Contact: Tracy Appel
Phone: (02) 9873 8559
Fax: (02) 9873 8550
Email: Tracy.Appel@heritage.nsw.gov.au
Your ref: MP08_0103 MOD 2
Our ref: 10/03111

RE: SCG Stage 2 Noble/Bradman Stand Redevelopment MP08_0103 MOD 3

Thank you for referring the proposed modifications to the Sydney Cricket Ground Stage 2 Noble/Bradman Stand Redevelopment, to the Heritage Council for assessment.

Drawing Number D-08C

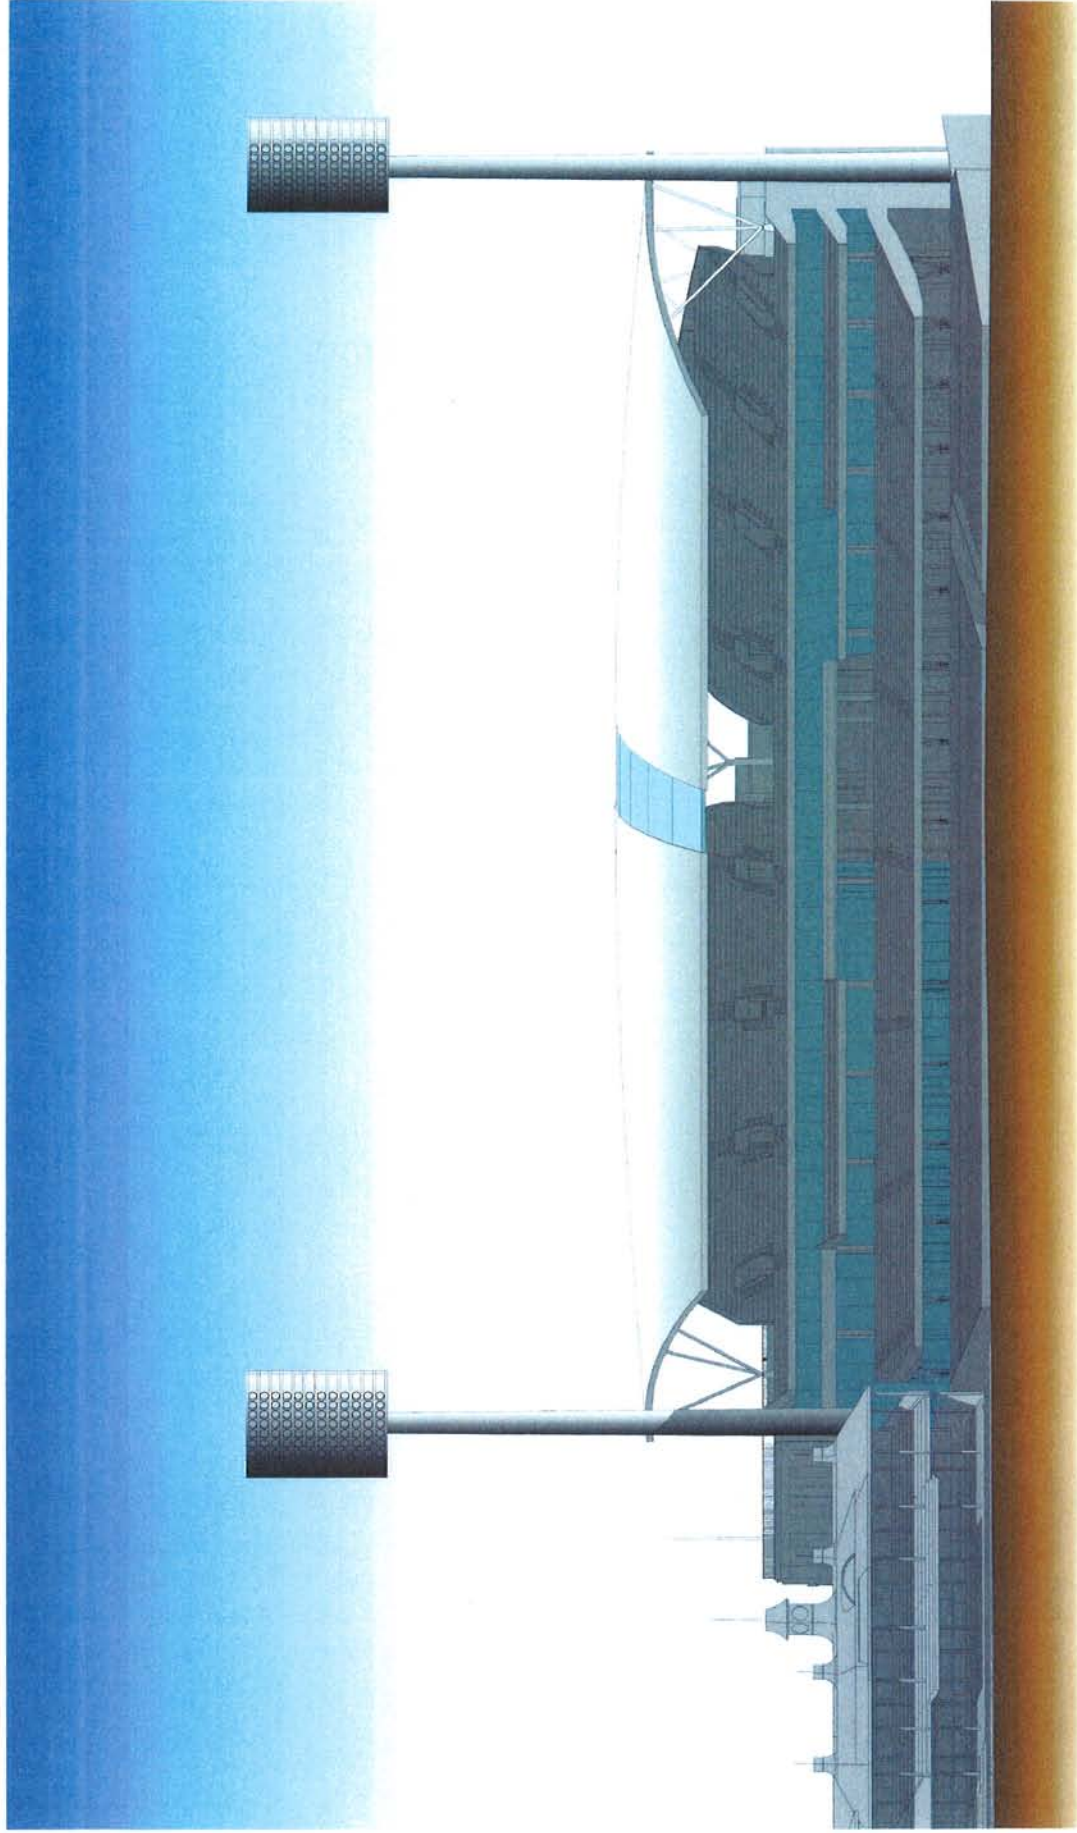
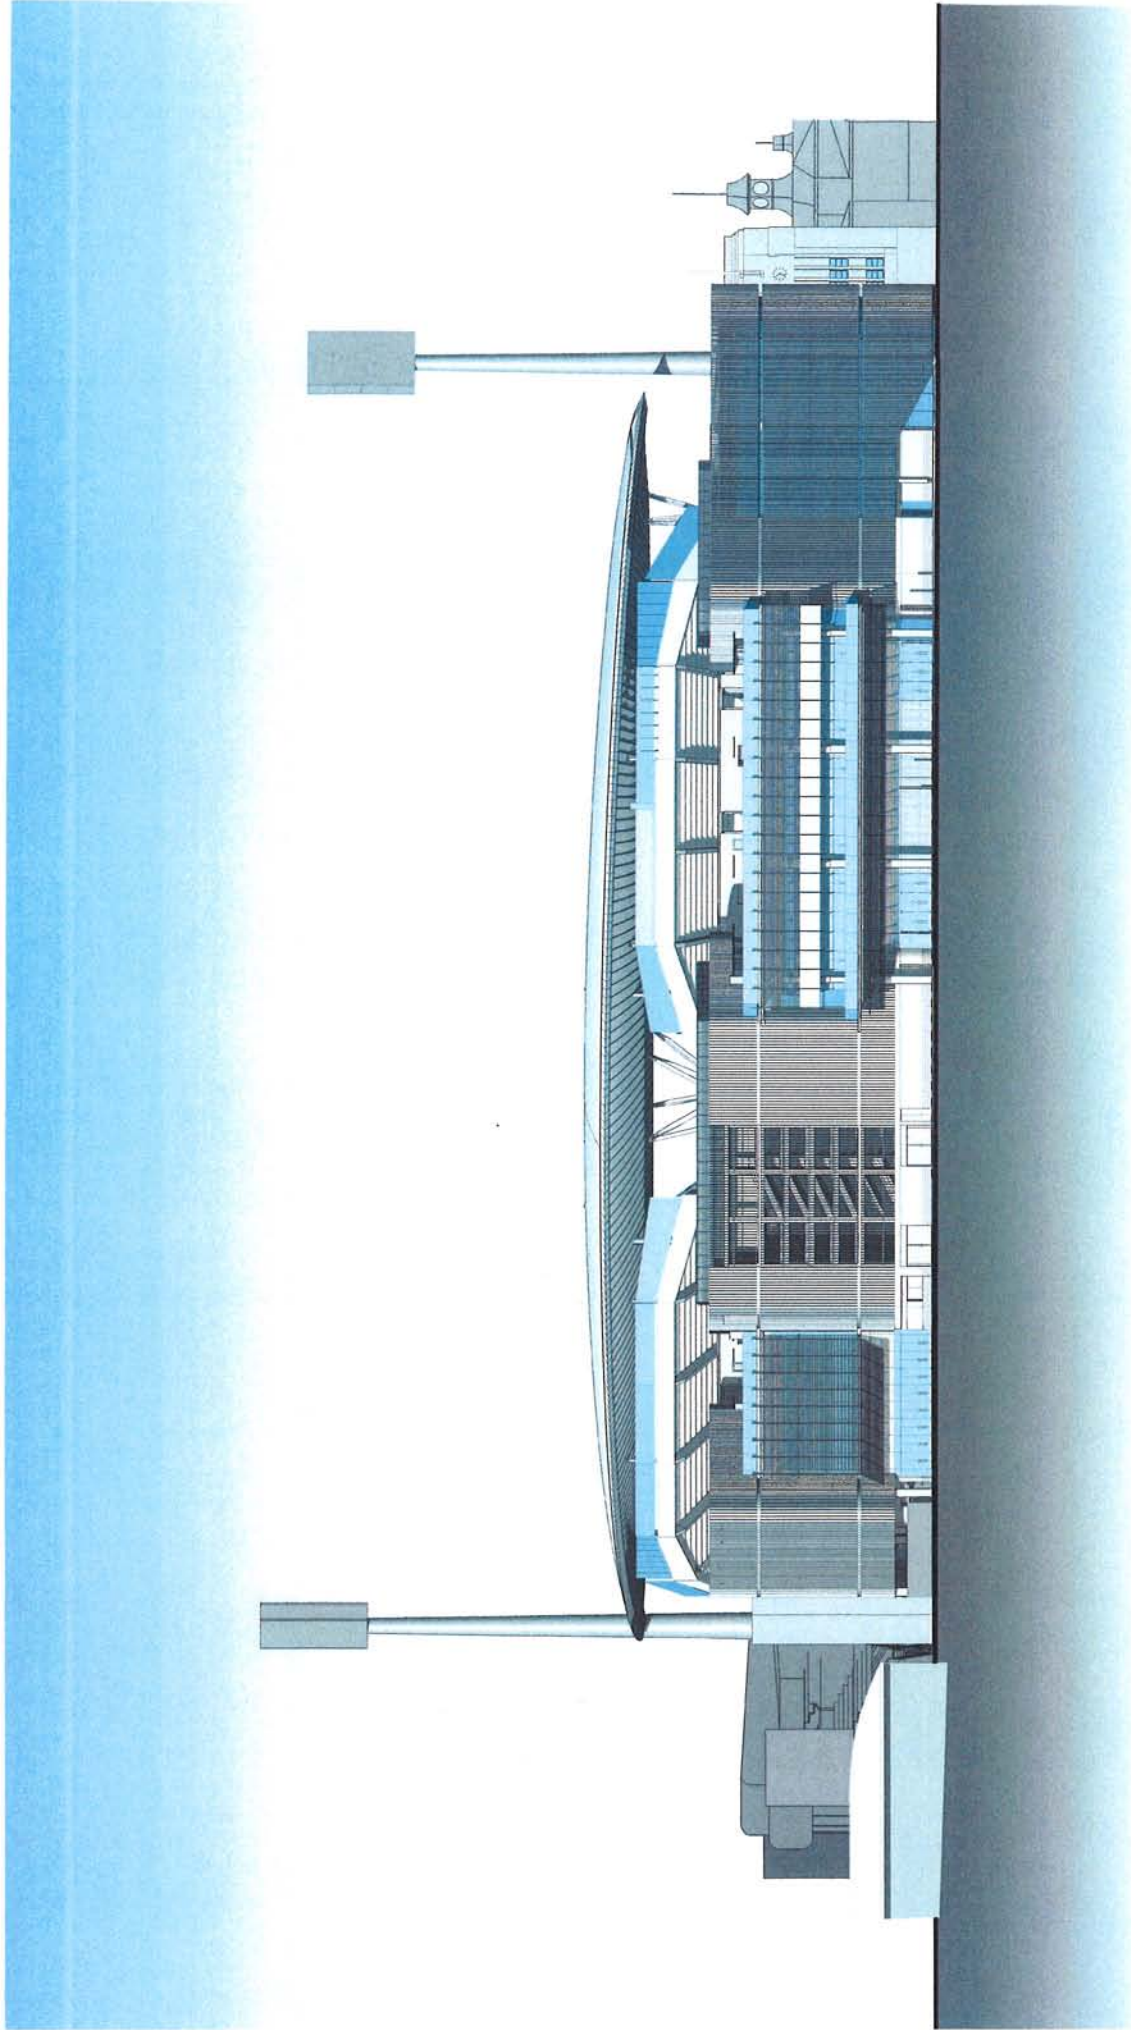
- Storage area added between the proposed stand and ground floor of the Western Tower, the plant removed;
- A new design for the roof which is more enclosed than the previously approved design. The eastern edge is less transparent with only one section on the leading edge facing the oval being transparent. The leading edge of the roof will be 4.99m higher than what has been previously approved;

- Extension of the northern building line further north by approximately 5m forward of the retained Western Tower;
- The new stand is more enclosed on the west at the upper level
- A minor re-orientation of the video scoreboard with the consequence that it projects beyond the SCG boundary. There are existing buildings immediately east of the proposed new grandstand within Fox Studios (Fox Buildings 24, 25 & 26). The applicant has stated that these buildings have been identified by Fox Studios Australia as being capable of demolition and redevelopment and that they have no heritage significance;
- Modifications to glazing on north and west elevation of the proposed stand.

1. The interpretation plan (Stage 2 & 3) for the site should be referred to the Heritage Council for comment;
2. The Heritage Council is to provide comment at the final design phase on the articulation, materials and colour of the new stand to ensure that they are sympathetic to adjacent heritage items;
3. The landscape design should be referred to the Heritage Council for comment;
4. All construction contractors, subcontractors and personnel are to be inducted and informed by the nominated heritage consultant prior to the commencement of work on site as to their obligations and requirements in relation to historical archaeological sites and 'relics' in accordance with guidelines issued by the Heritage Council;
5. The mitigation measures detailed in the Heritage Impact Assessment prepared by Godden Mackay Logan must be implemented.

Drawing Title: SOUTH ELEVATION  
 Drawing Number: D-09C  
 Date: 15/10/2012

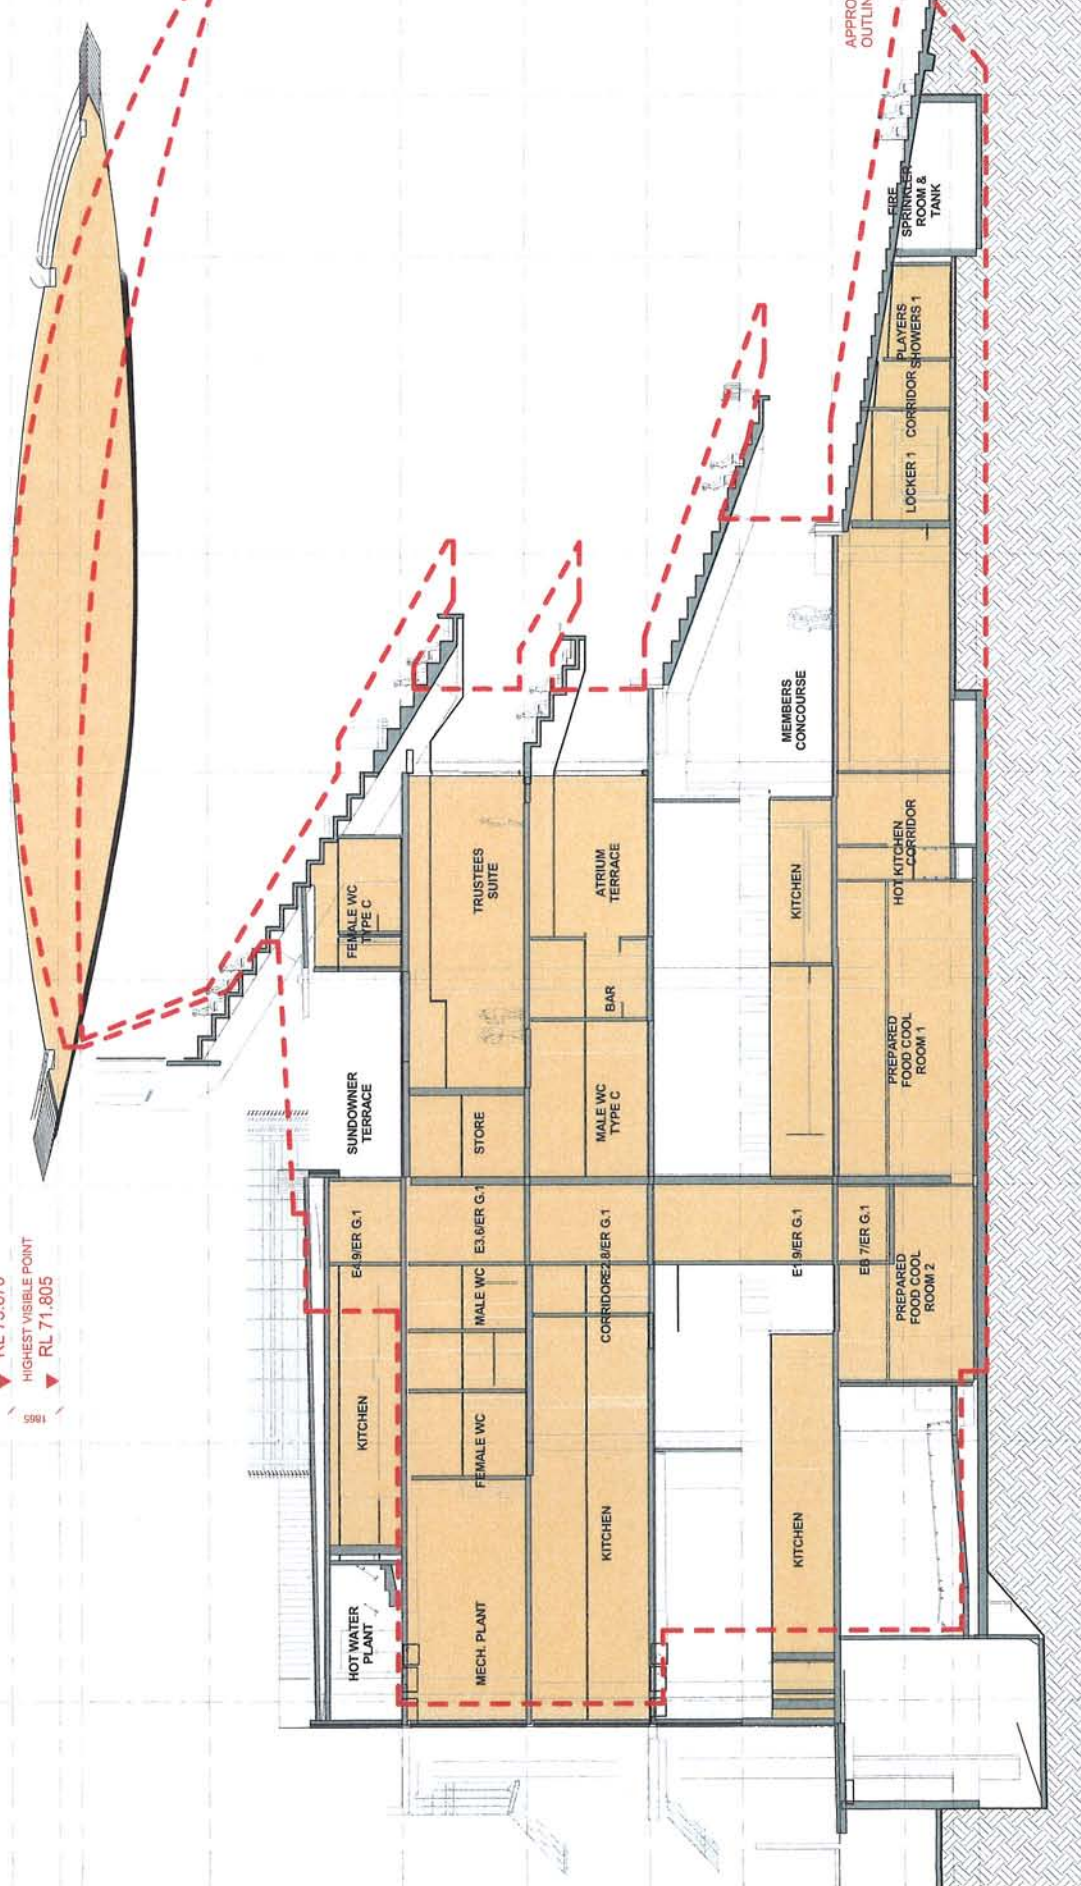
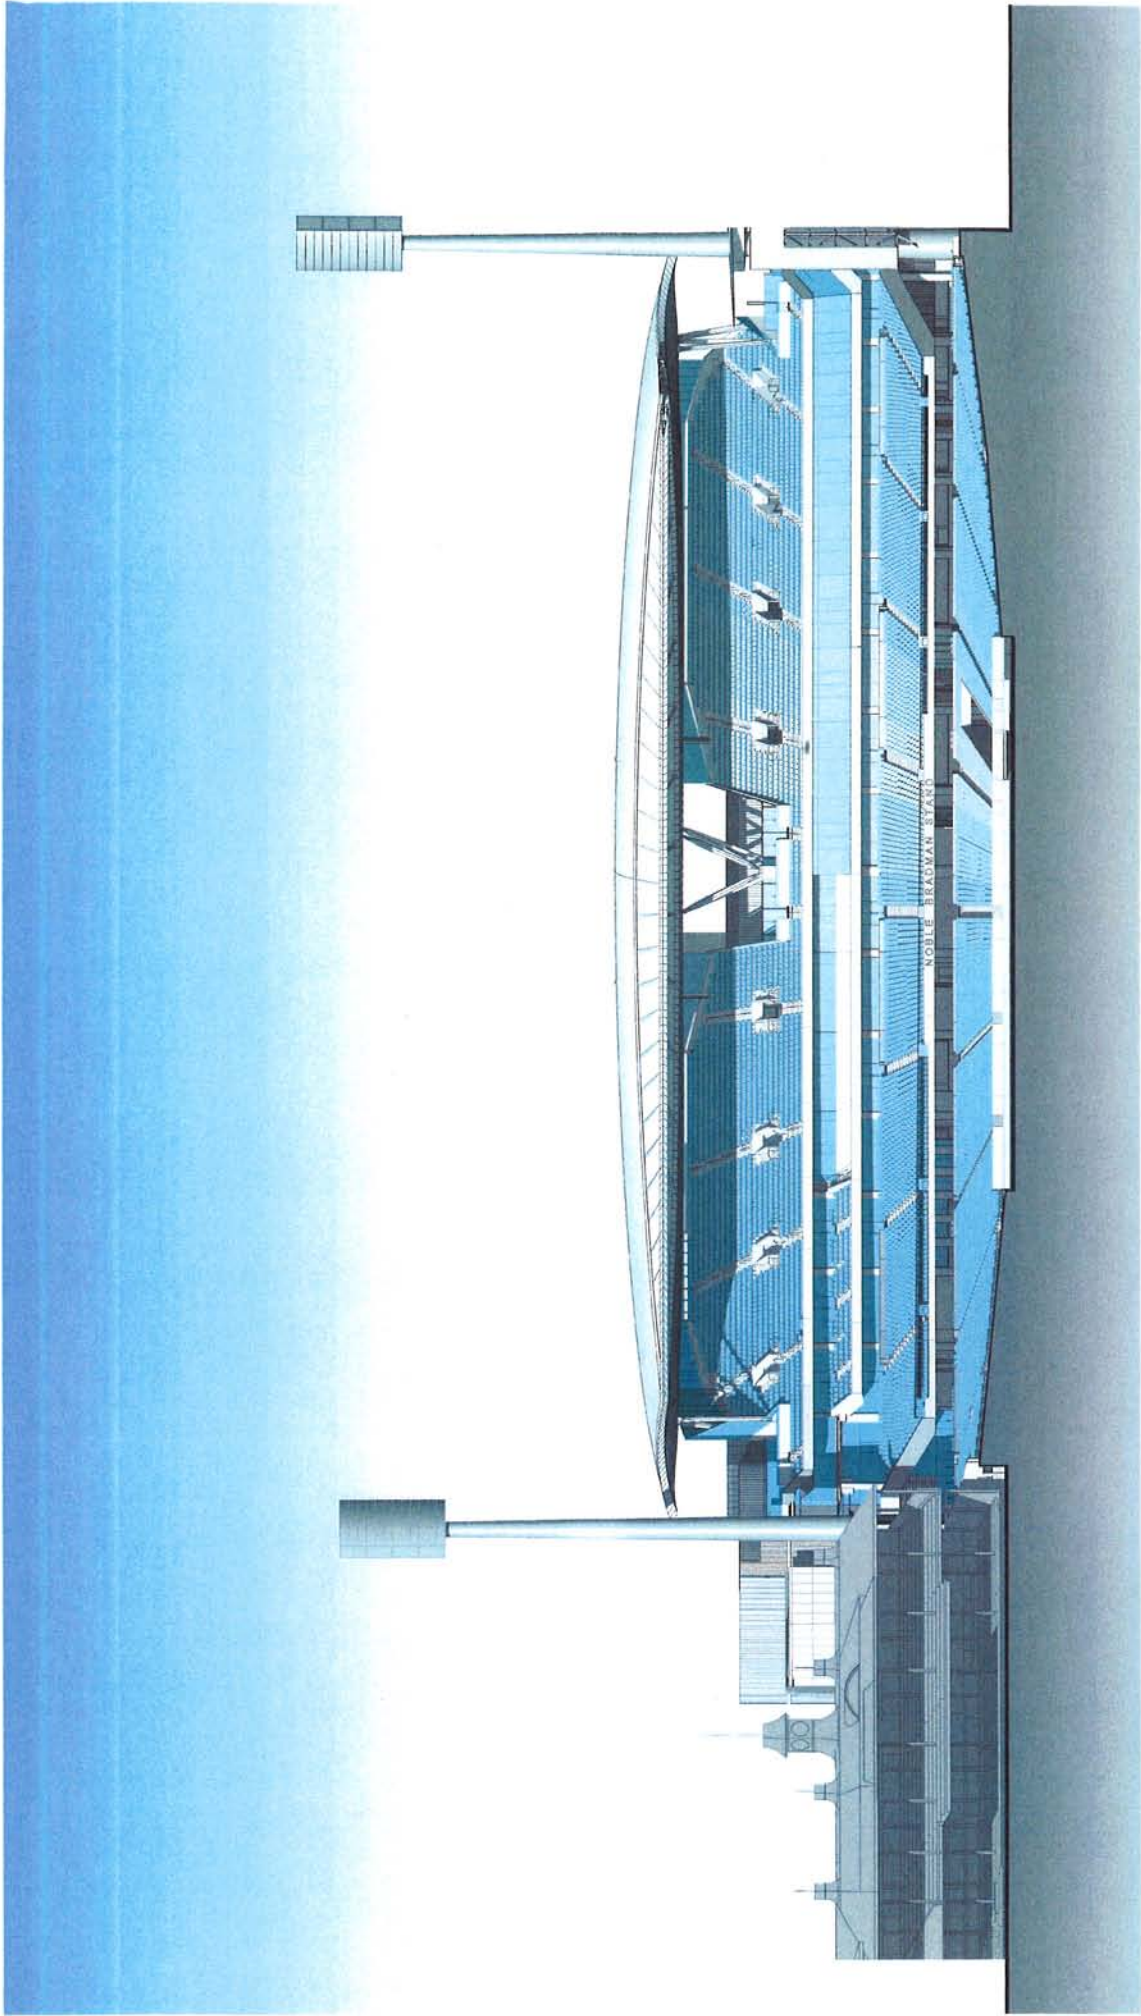
- Temporary cladding on the west and south sides of the Tower will be replaced by perforated metal instead of terracotta and glass walls;
- The design of the proposed stand is less stepped and taller beside the Western Tower;
